From: ANTHONY CHAFER <[REDACTED]>
Sent: 30 March 2023 08:47
To: Aquind Interconnector
Subject: Aquind - objection
Categories: Consultation Response

Dear Planning Inspectorate

TITLE: Application document reference 2.10 Indicative Optical Regeneration Station(s) Elevations and Floor Plans Sheet 1 of 4

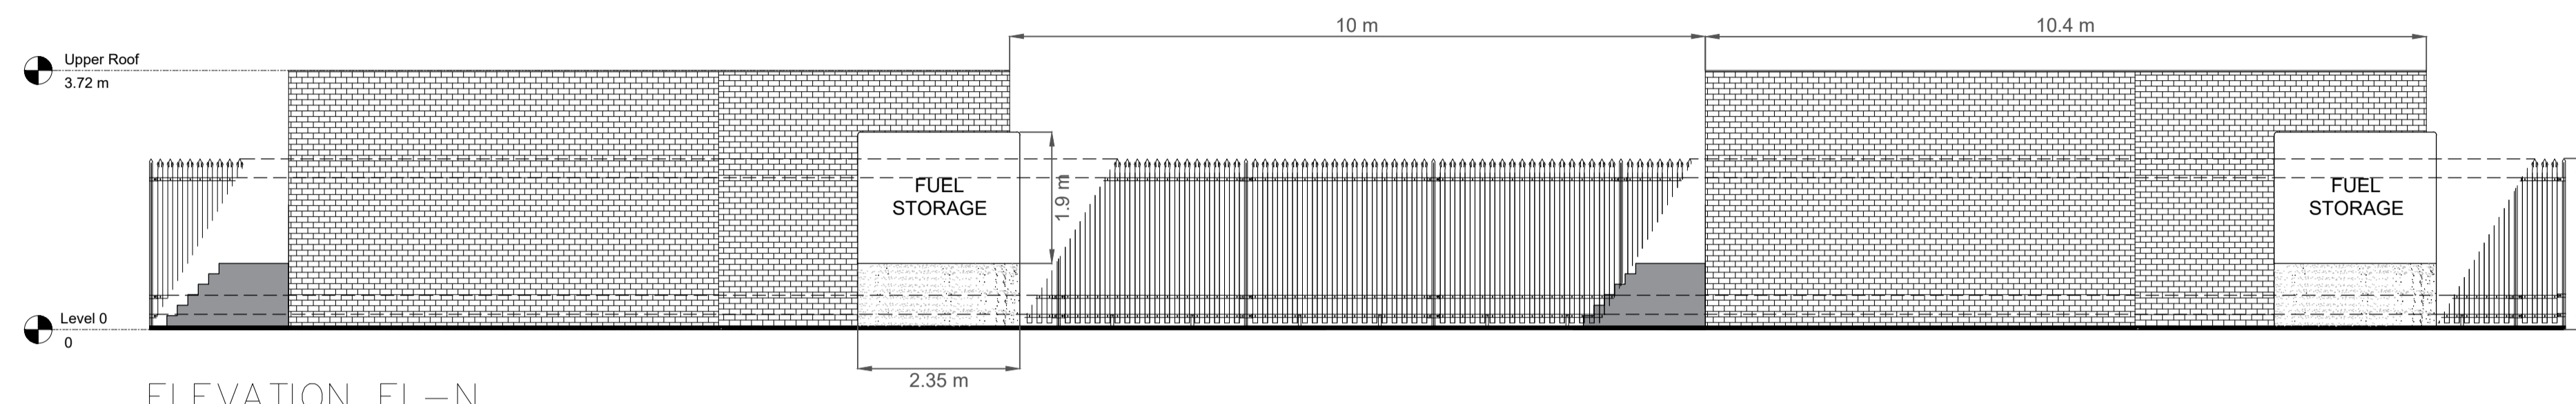
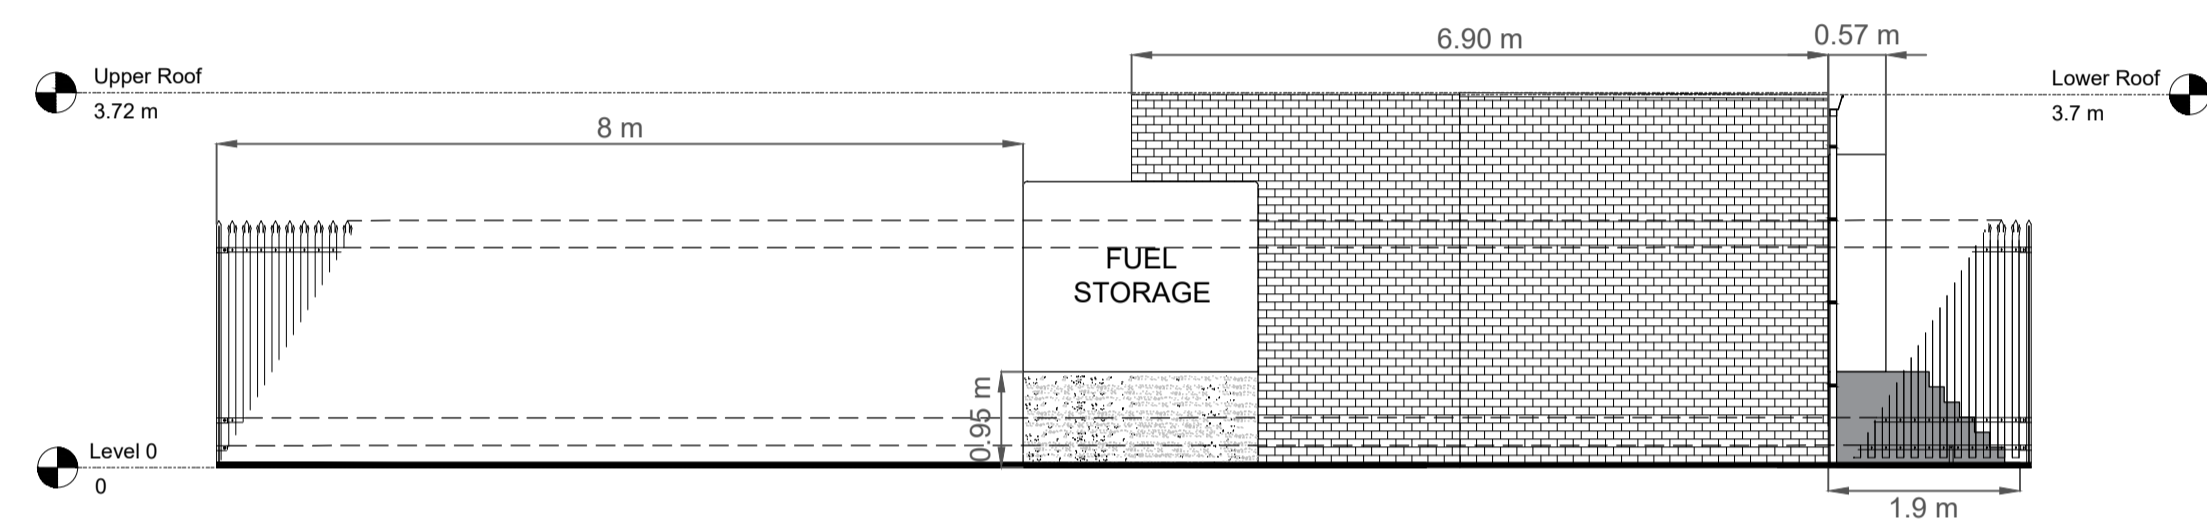
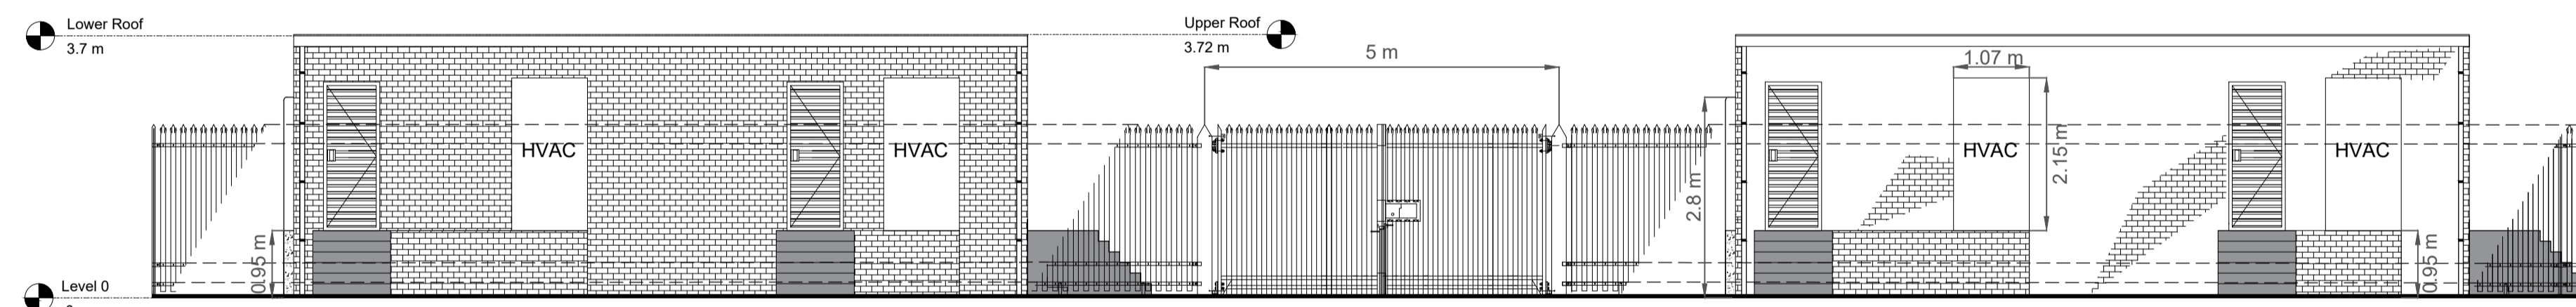
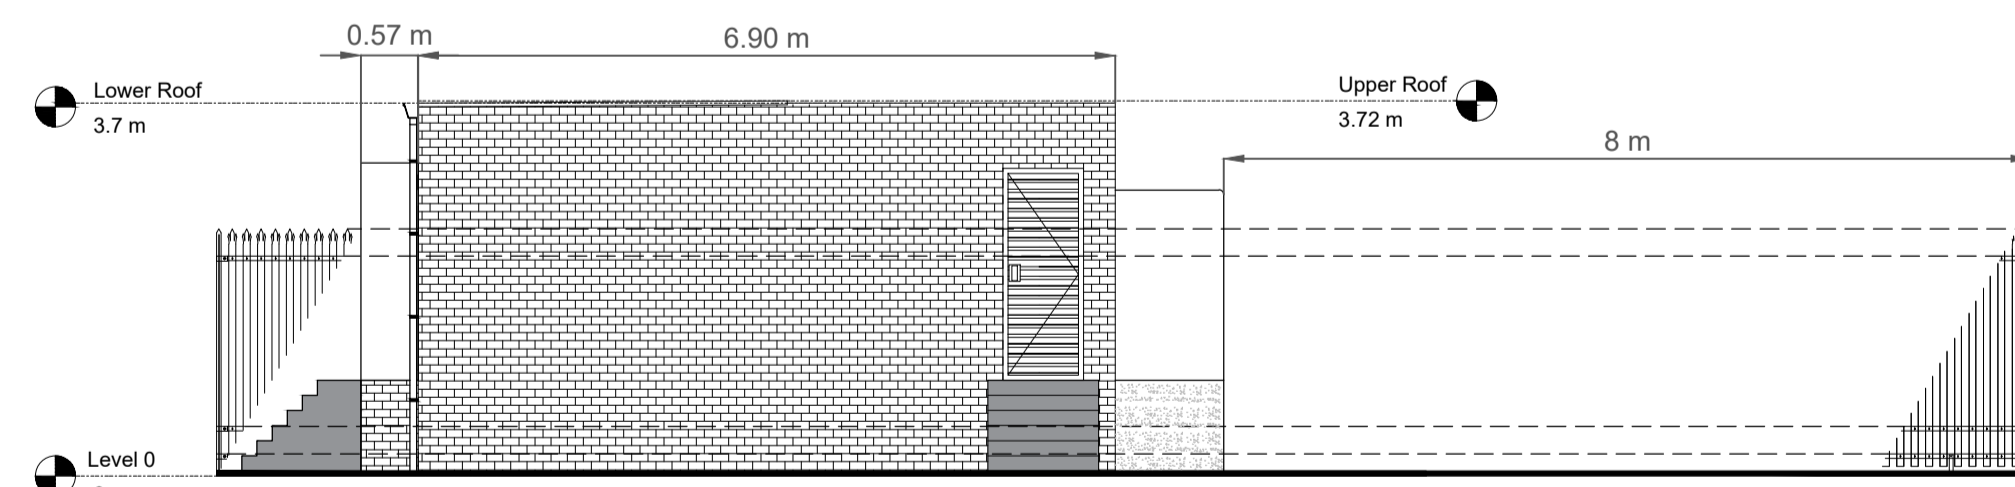
2. I am concerned about above-ground buildings at Eastney. Aquind are planning to have a compound at the junction of Fort Cumberland Road and Melville Road housing an "Optical regeneration station". This site will have buildings 3.72m high (about 12') and have a site footprint of 35m x 18m – quite significant close to the seafront – why does it have to be above ground and located there? Also there are 2 x diesel generators on this site, relatively close to housing, what about noise etc and visual impact in general?

Compulsory Aquisition Hearing 1 – Appendix 1
- Exhibit 15 Cross-section showing the typical
arrangement of the construction corridor
across Milton Common

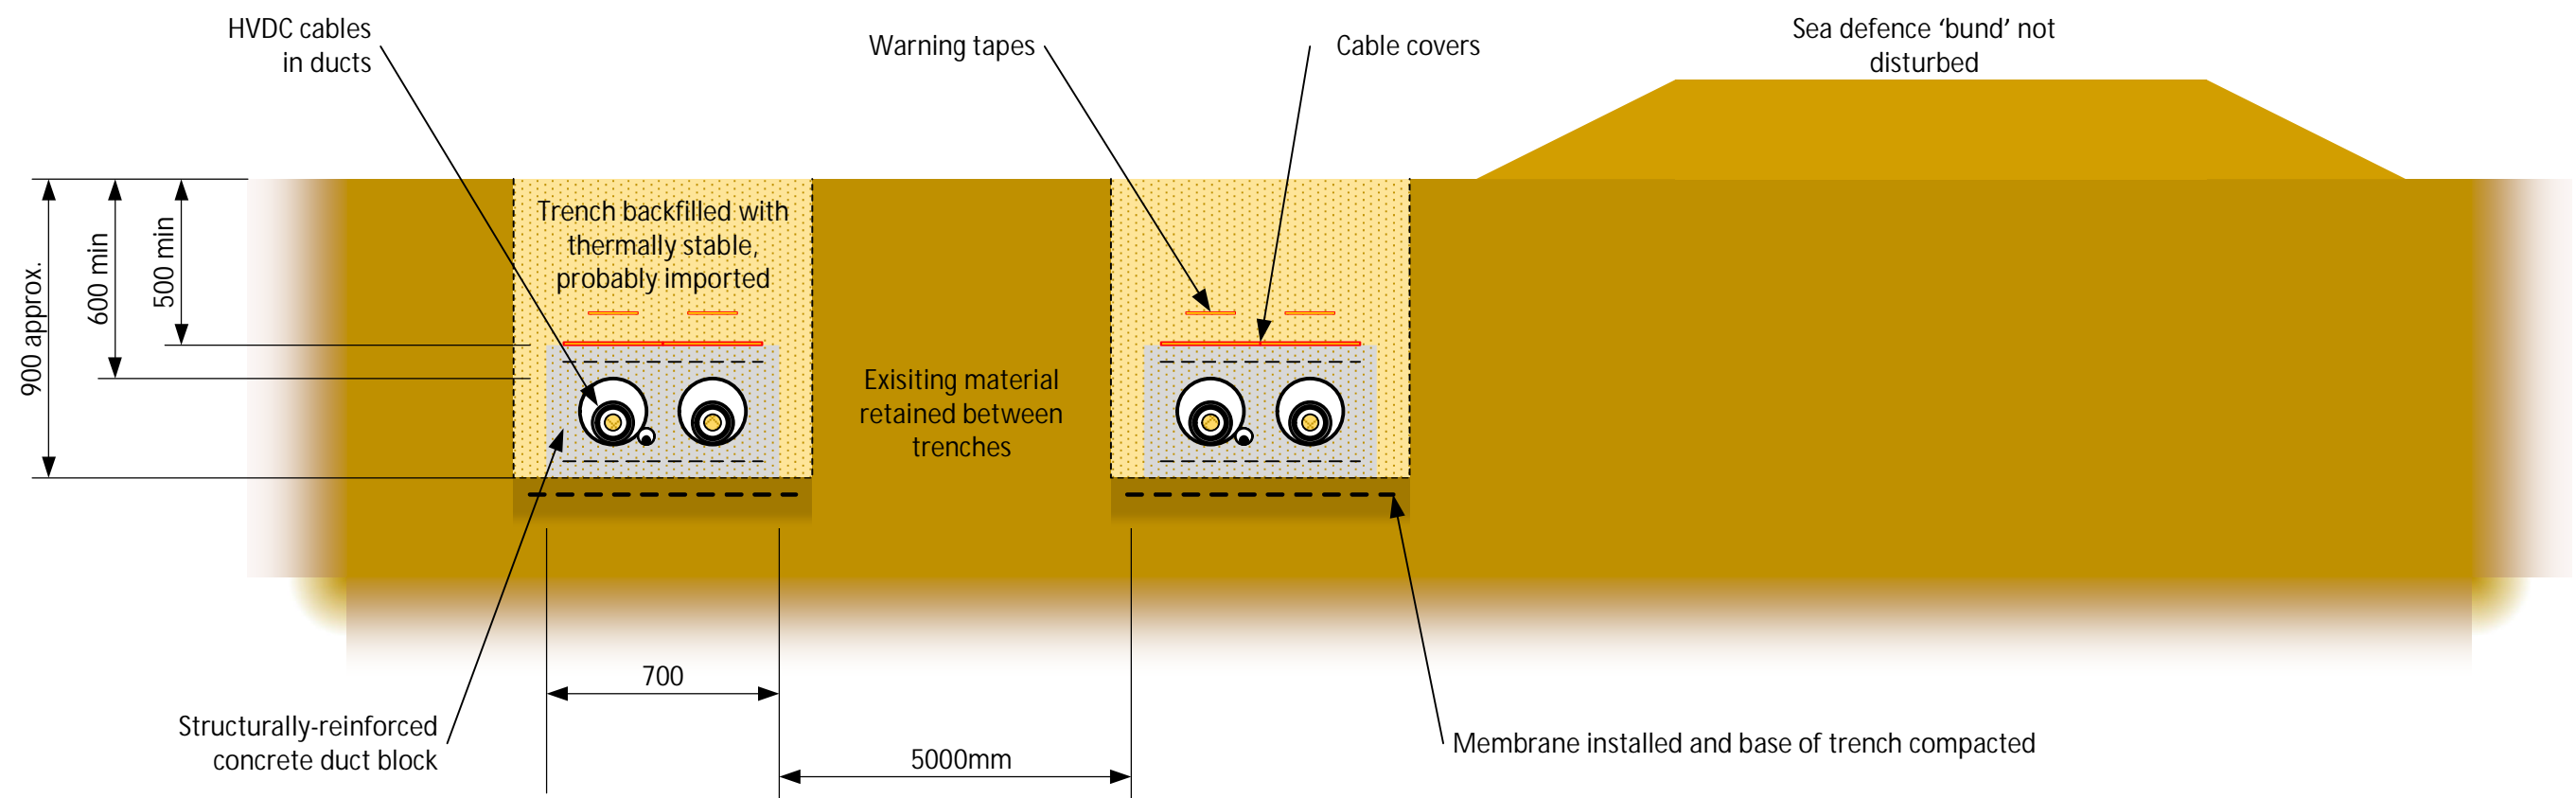
1. The plan to dig up Milton allotments. We were originally informed this would be by HDD (horizontal direct drilling). Now we are told they will dig up, lay and replace. This is not acceptable due to the damage to wildlife, flora and fauna that it will cause (including felling of trees). Moreover, Milton allotments were not part of the original consultation, yet this area is now included.
